FULL PLANNING PERMISSION

Reference: H05-0586-15 **Date of Decision:** 29th October 2015
Applicant: Sovereign Homes (UK) Ltd
Seagate Hall
Vicarage Lane
Long Sutton
Spalding
PE12 9AF
Location: Off Fleet Road Fleet Hargate Spalding
Description: Erection of 4 bedroom house and detached double garage

BLOCK PLAN.
1/250.

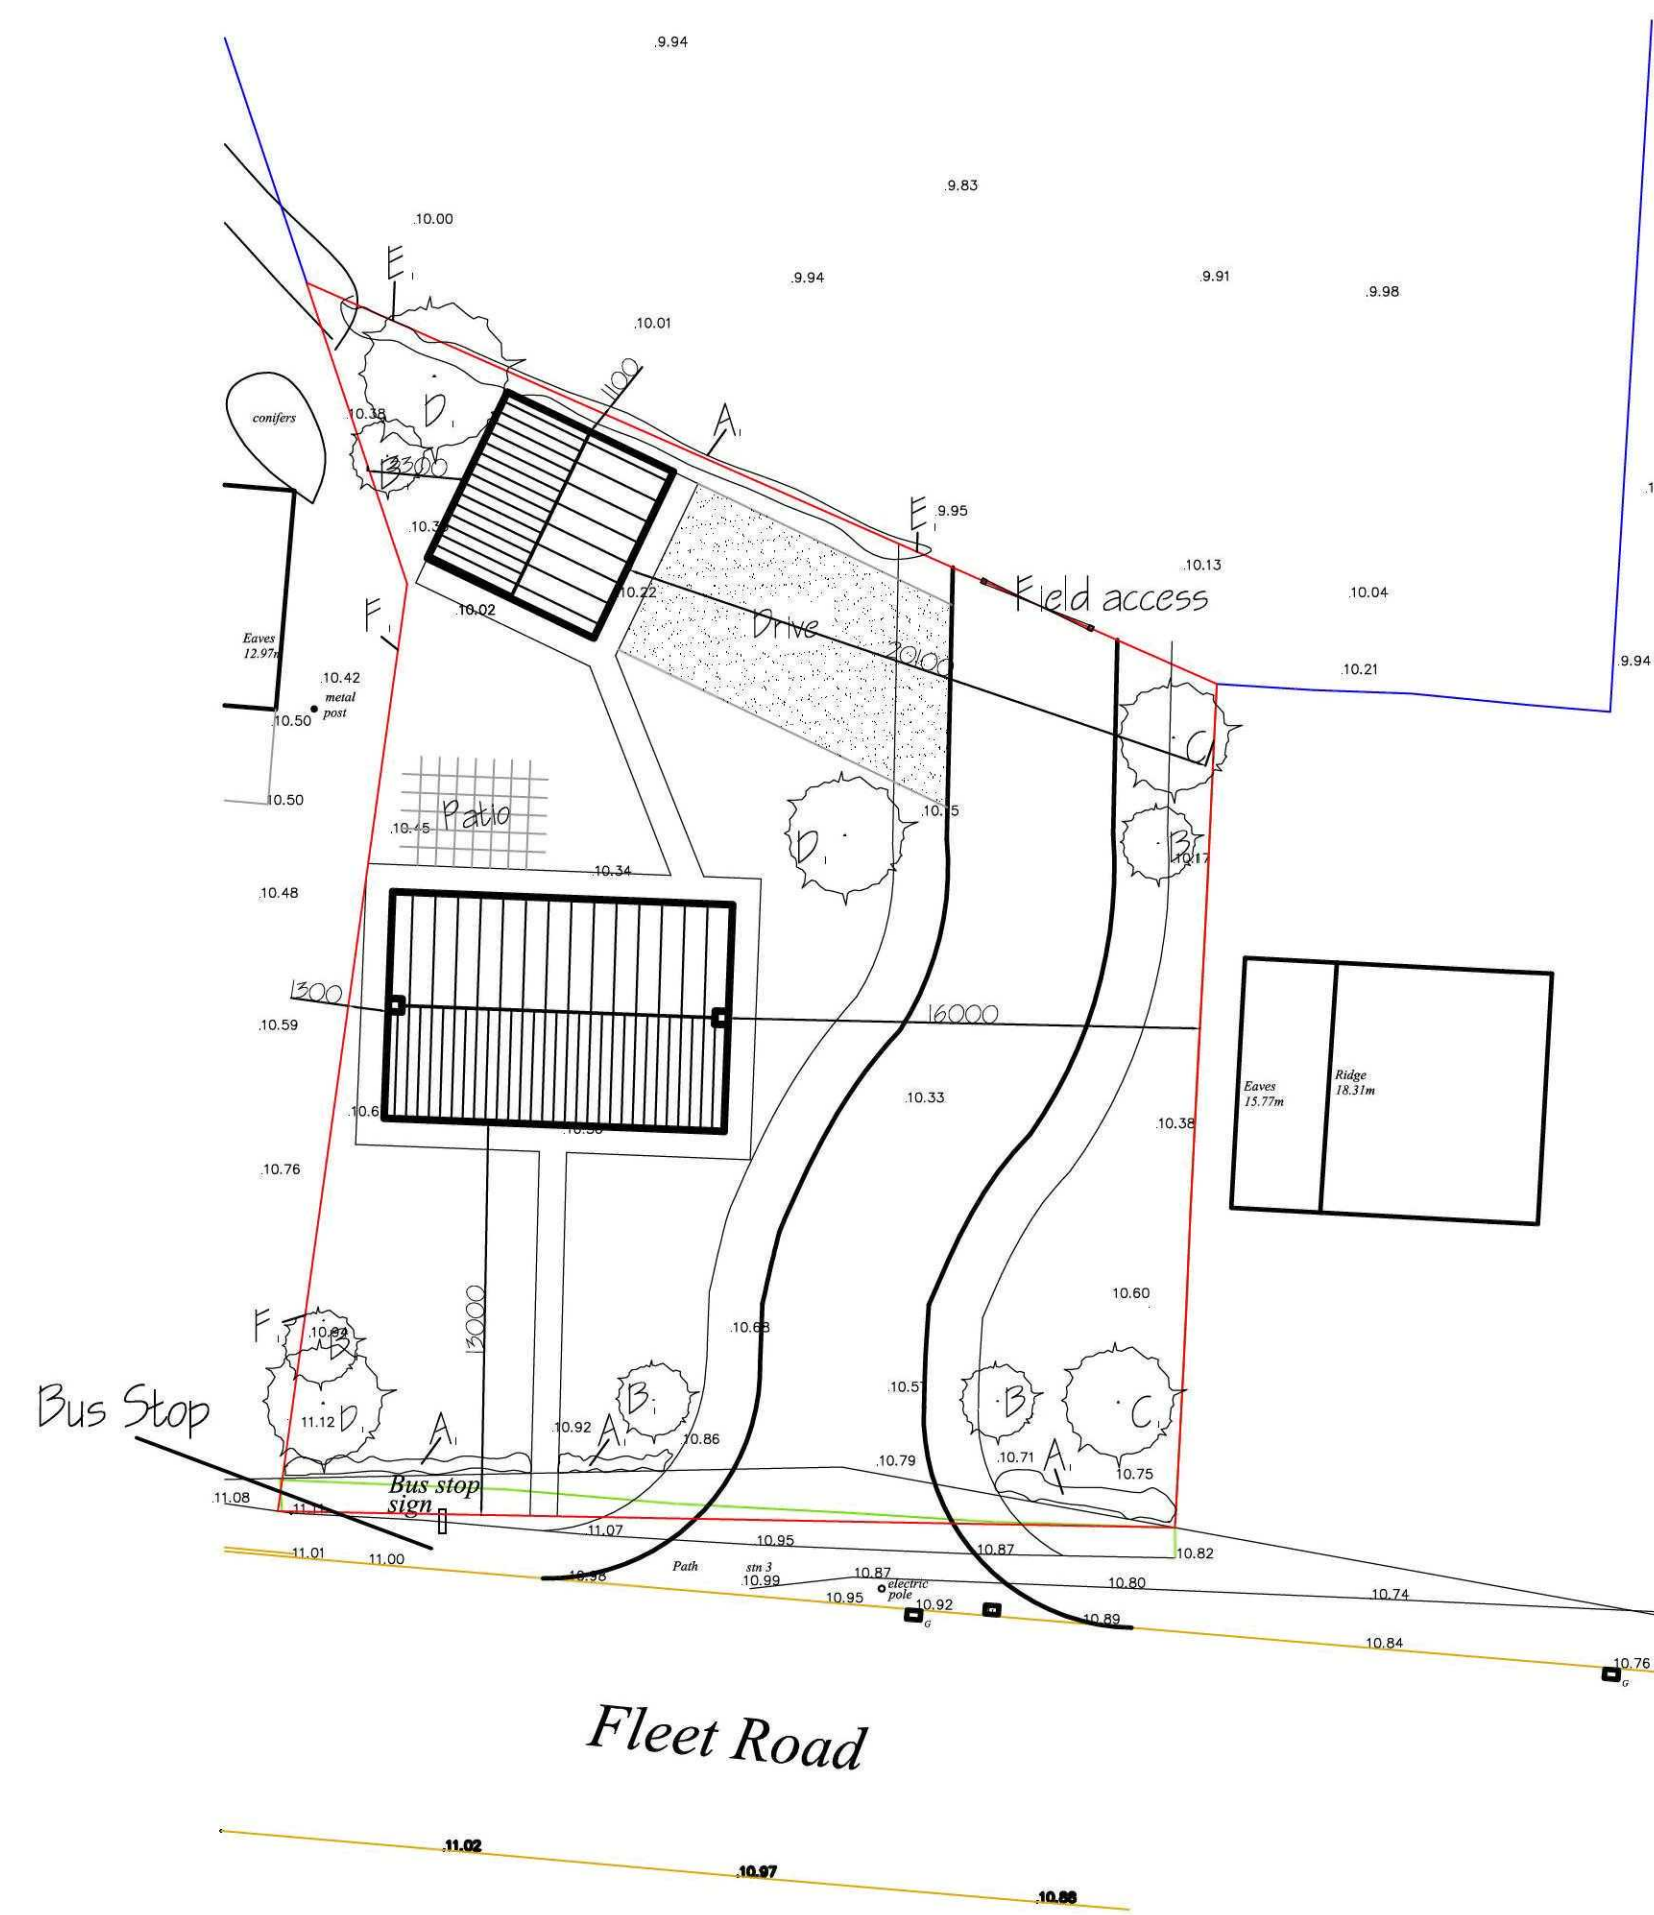
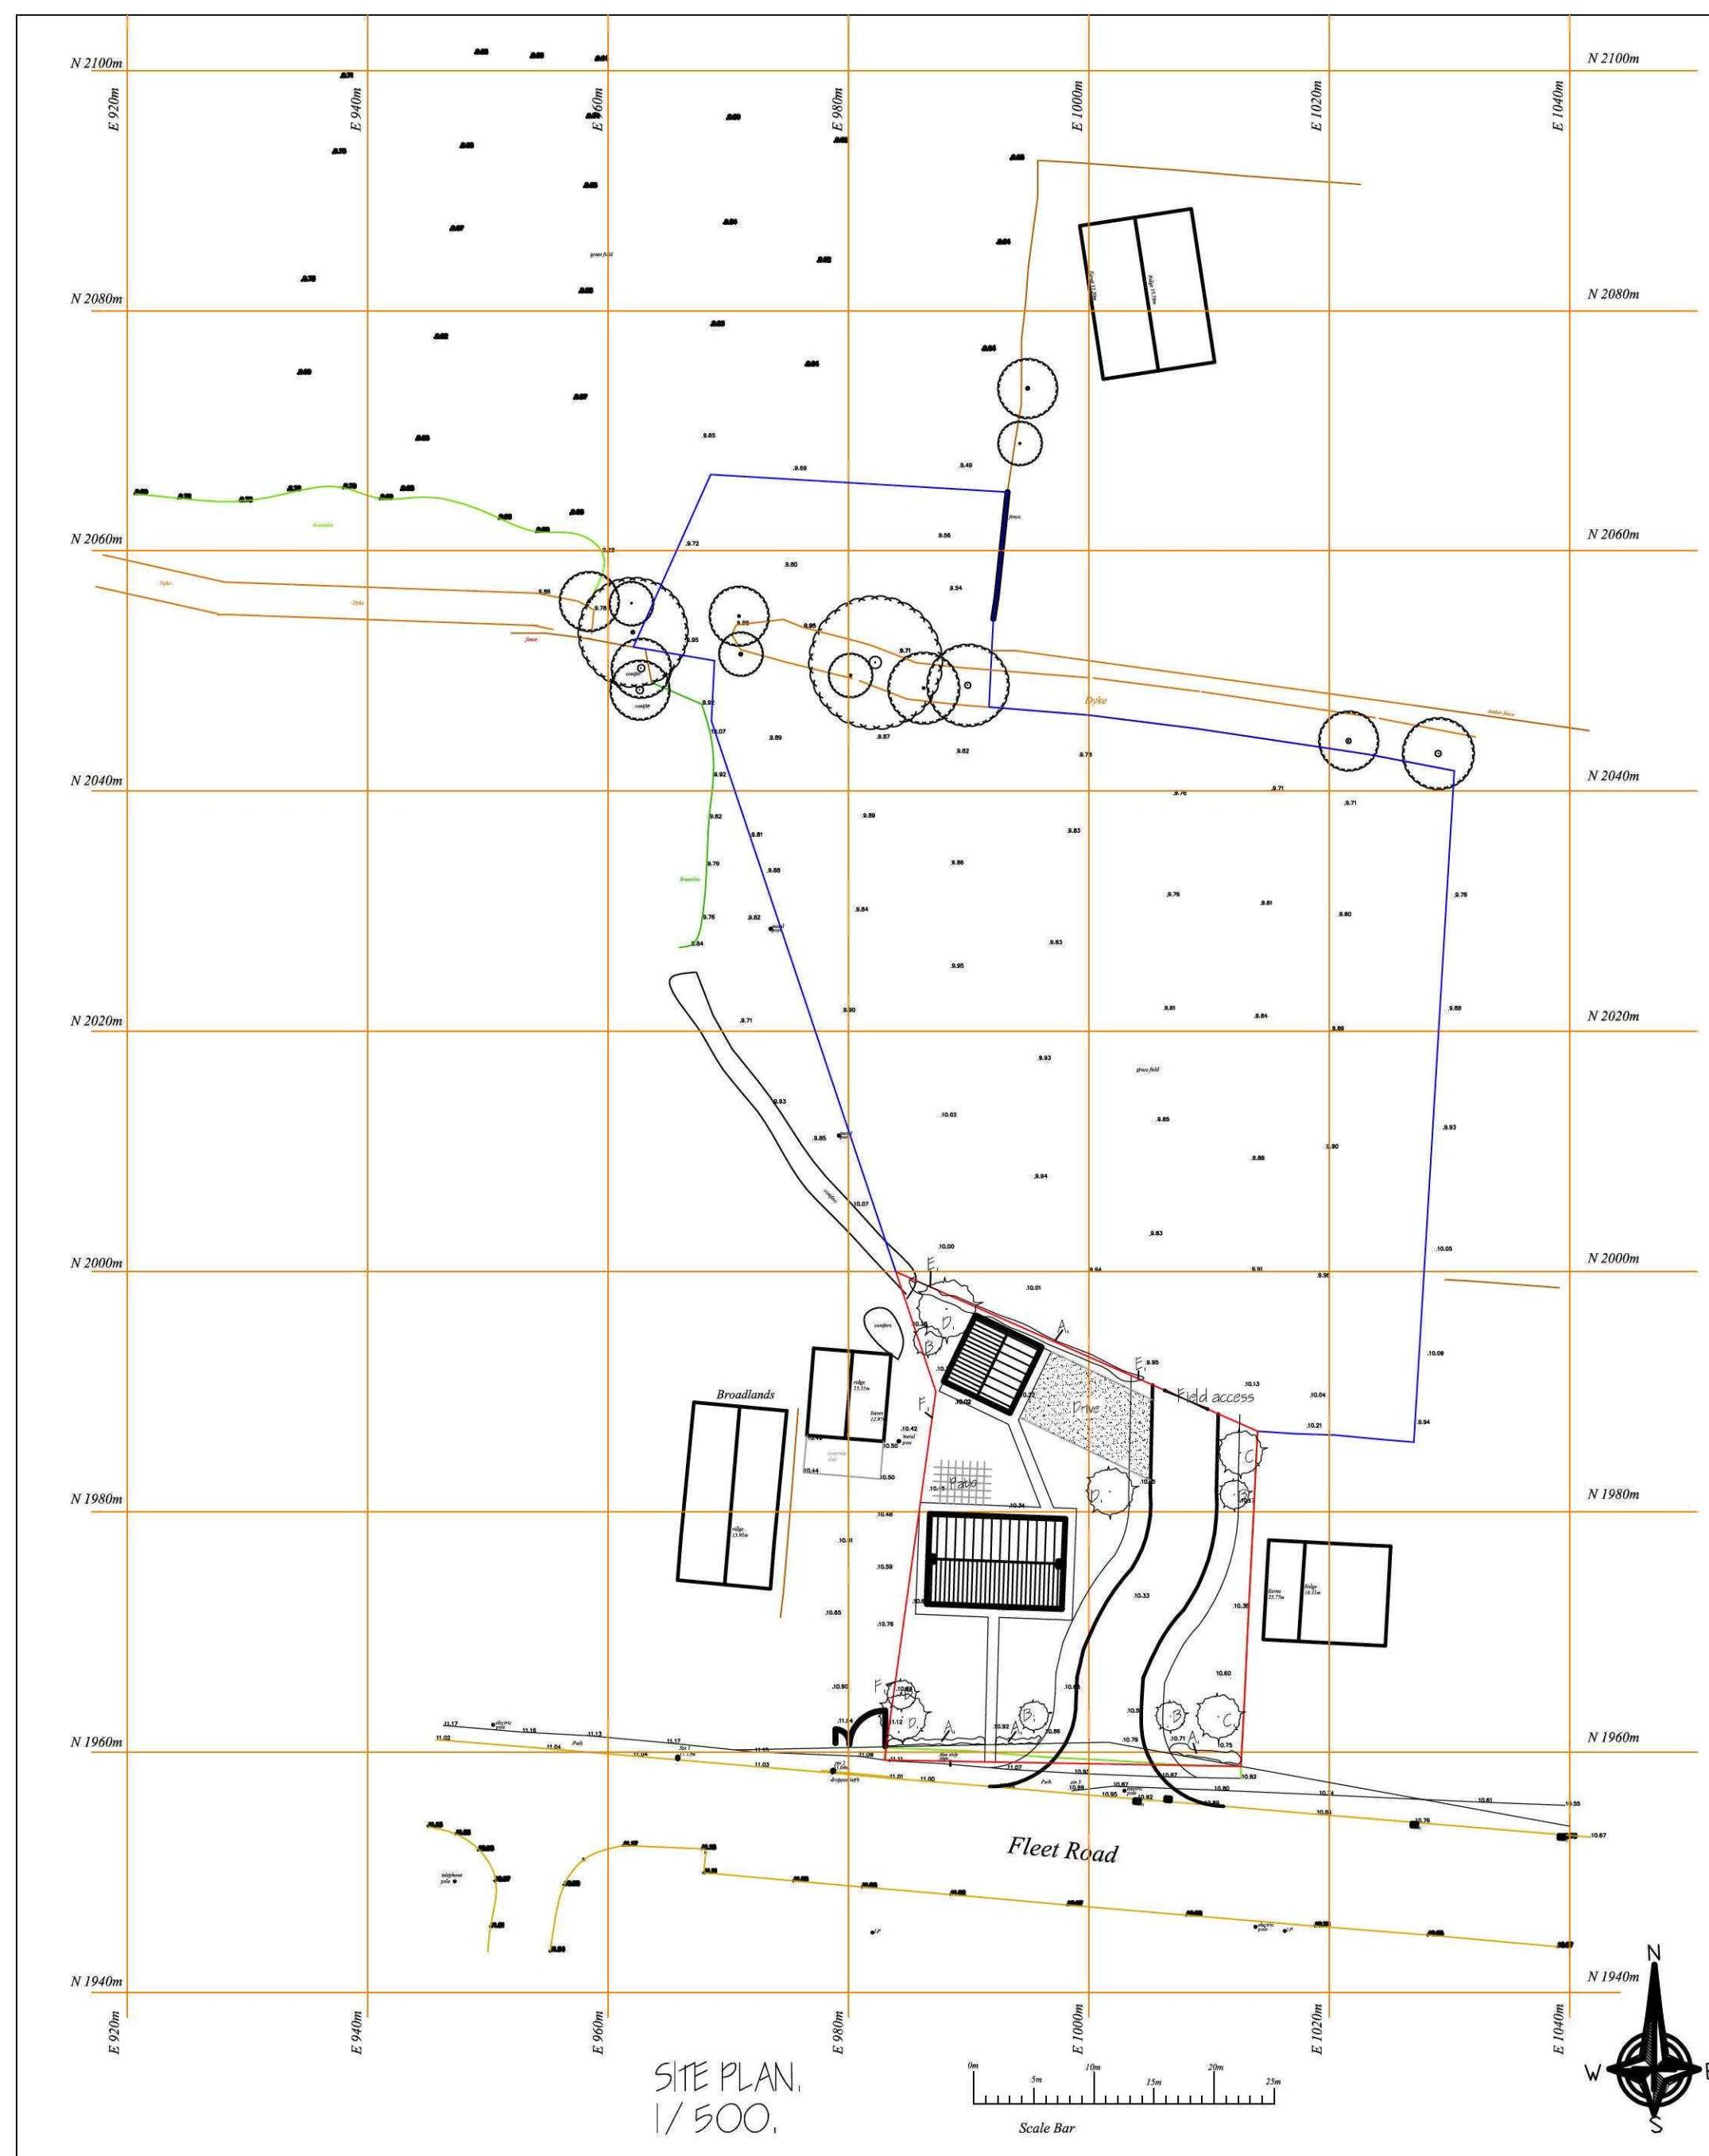
- 4 The scheme of landscaping and tree planting shown on dwg. no. 2200-10-10A received by the Local Planning Authority on 27 August 2015 shall be carried out in its entirety within a period of 12 months beginning with the date on which development is commenced. All trees, shrubs and bushes shall be maintained by the owner or owners of the land on which they are situated for the period of five years beginning with the date of completion of the scheme and during that period all losses shall be made good as and when necessary.

- 15 Before development is commenced beyond oversight, full details of screening along the eastern boundary of the site, including details of height and materials, shall be submitted to and approved in writing by the Local Planning Authority. The approved scheme of screening shall be implemented in full before the dwelling is occupied and thereafter retained in its entirety.
